October 4, 2010

**Re: James Monroe Middle School New Track Revised Grading and
Drainage Plan Engineer's Stamp dated 7-25-11 (B10/D004)**

A1 GRADING & DRAINAGE PLAN
SCALE: 1" = 30'

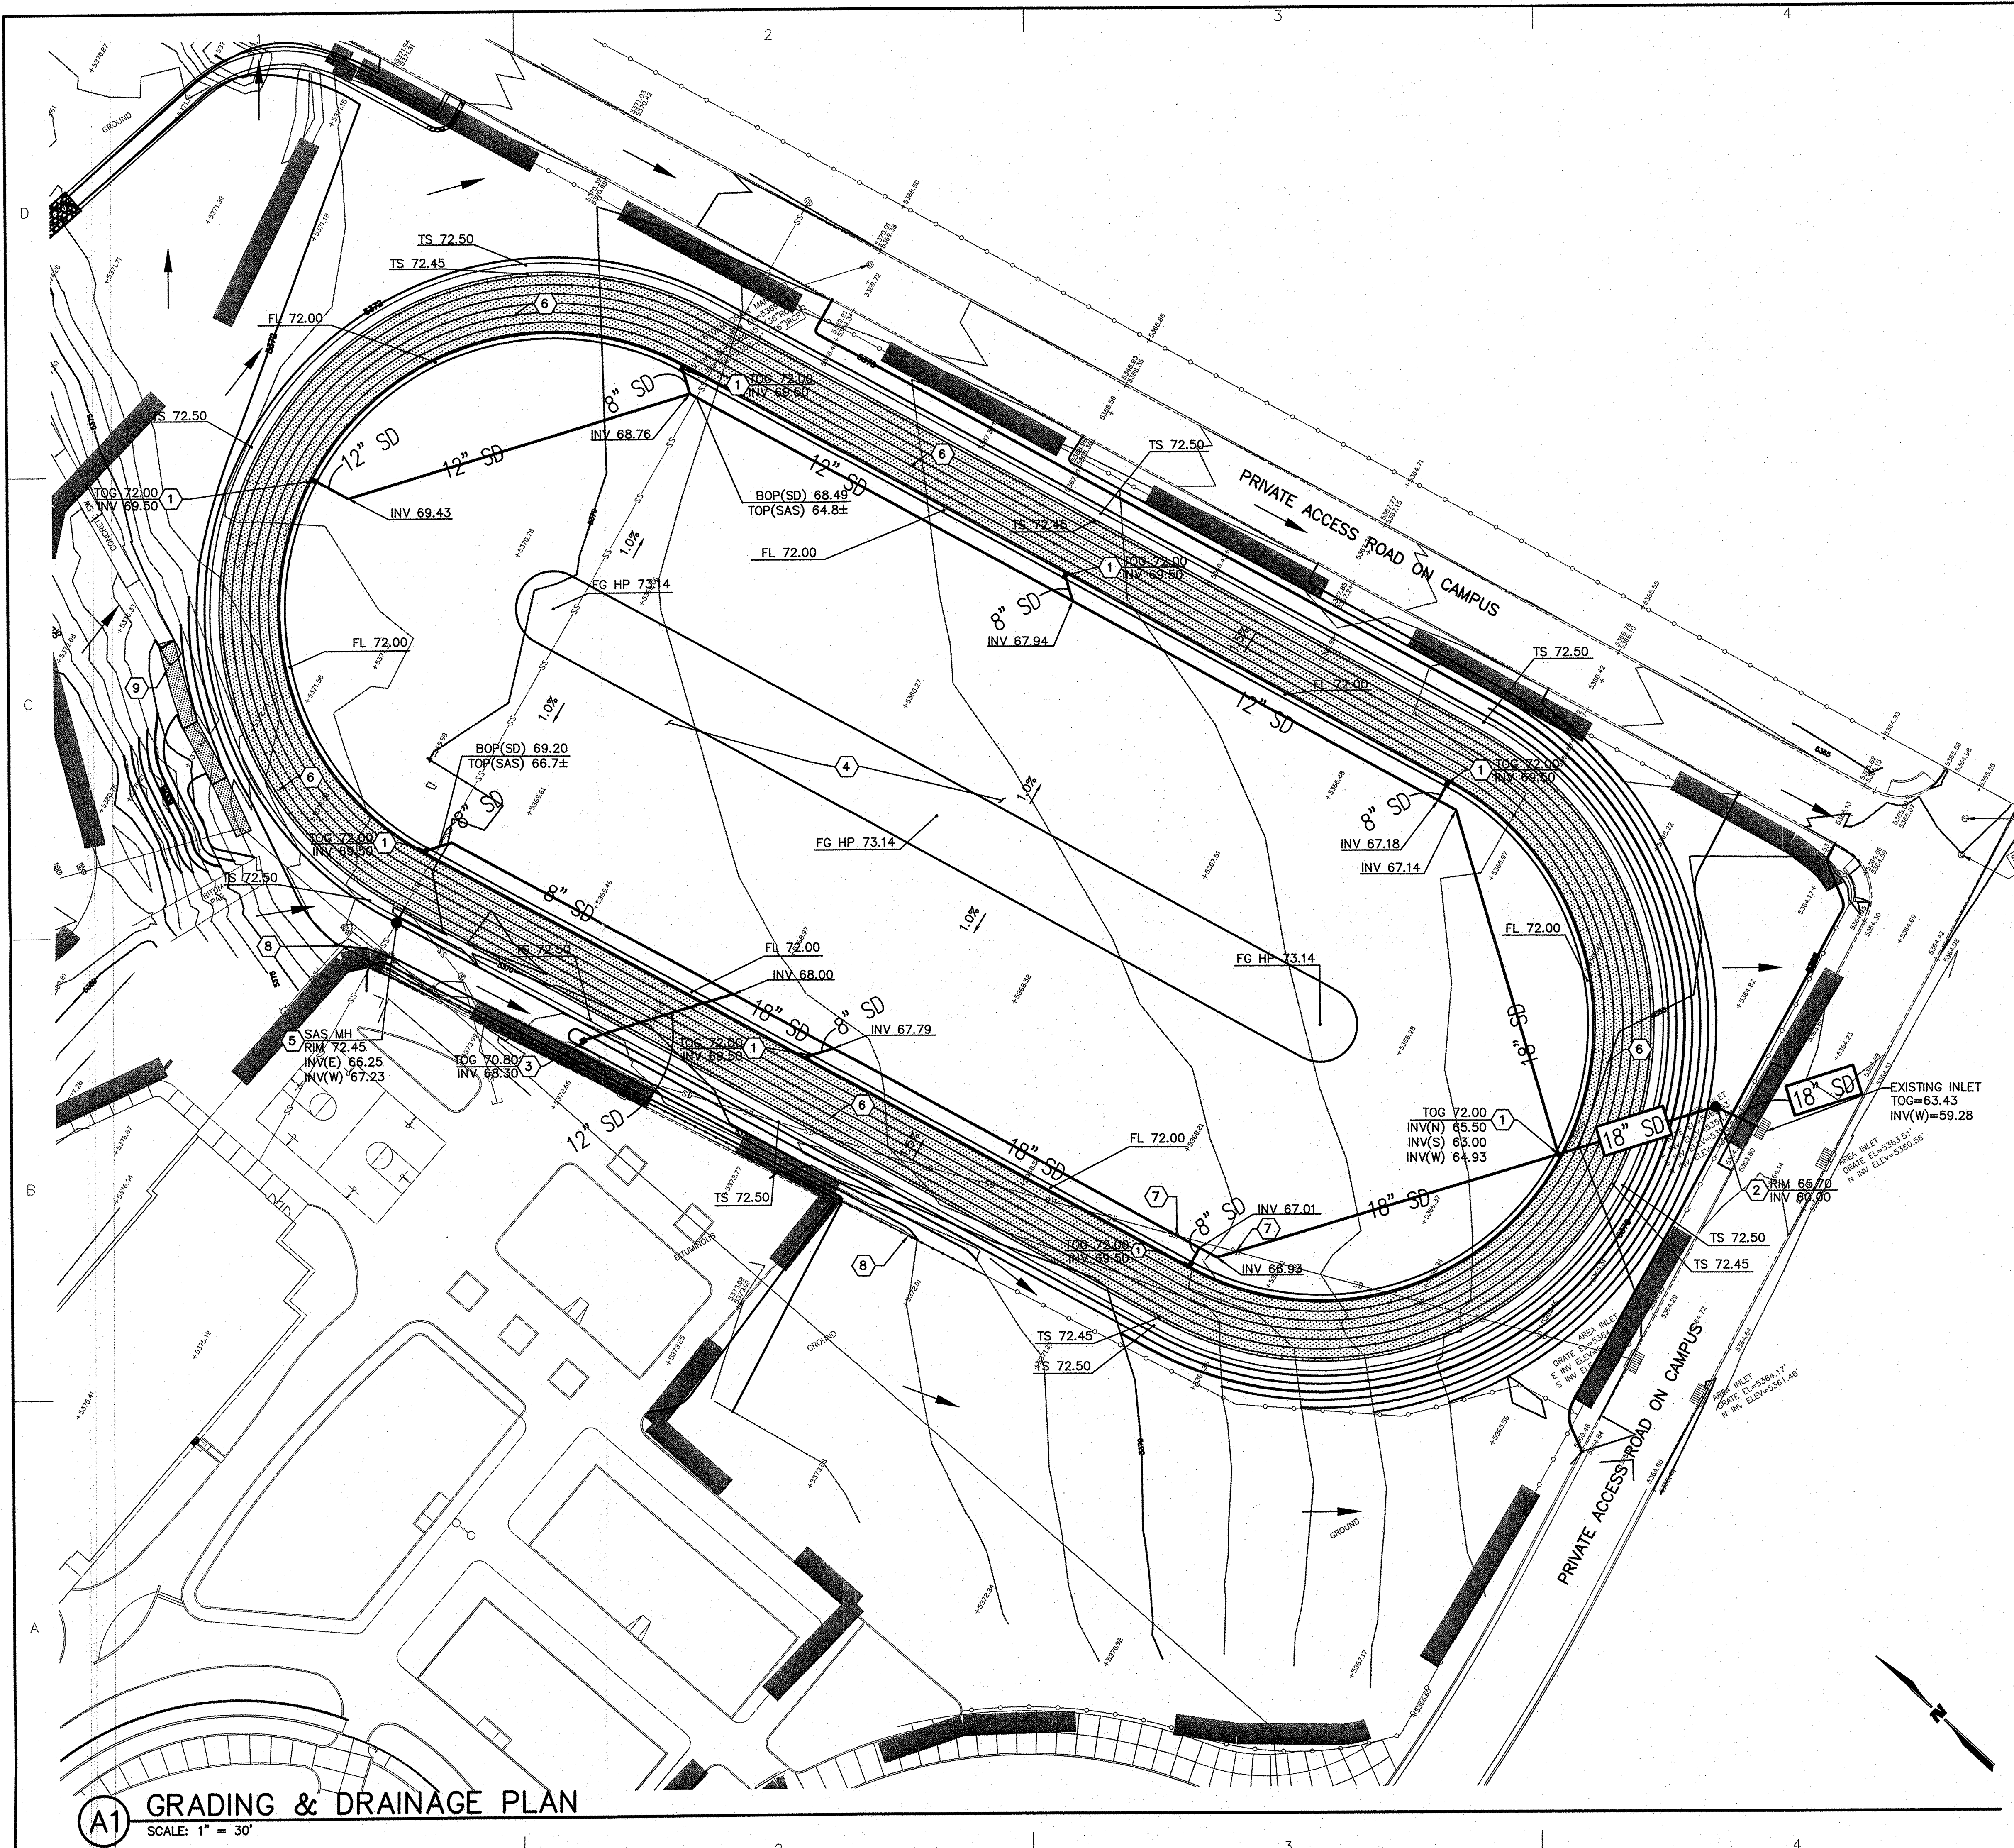
You may want to provide some means of erosion control on the slope around the south side of the track.
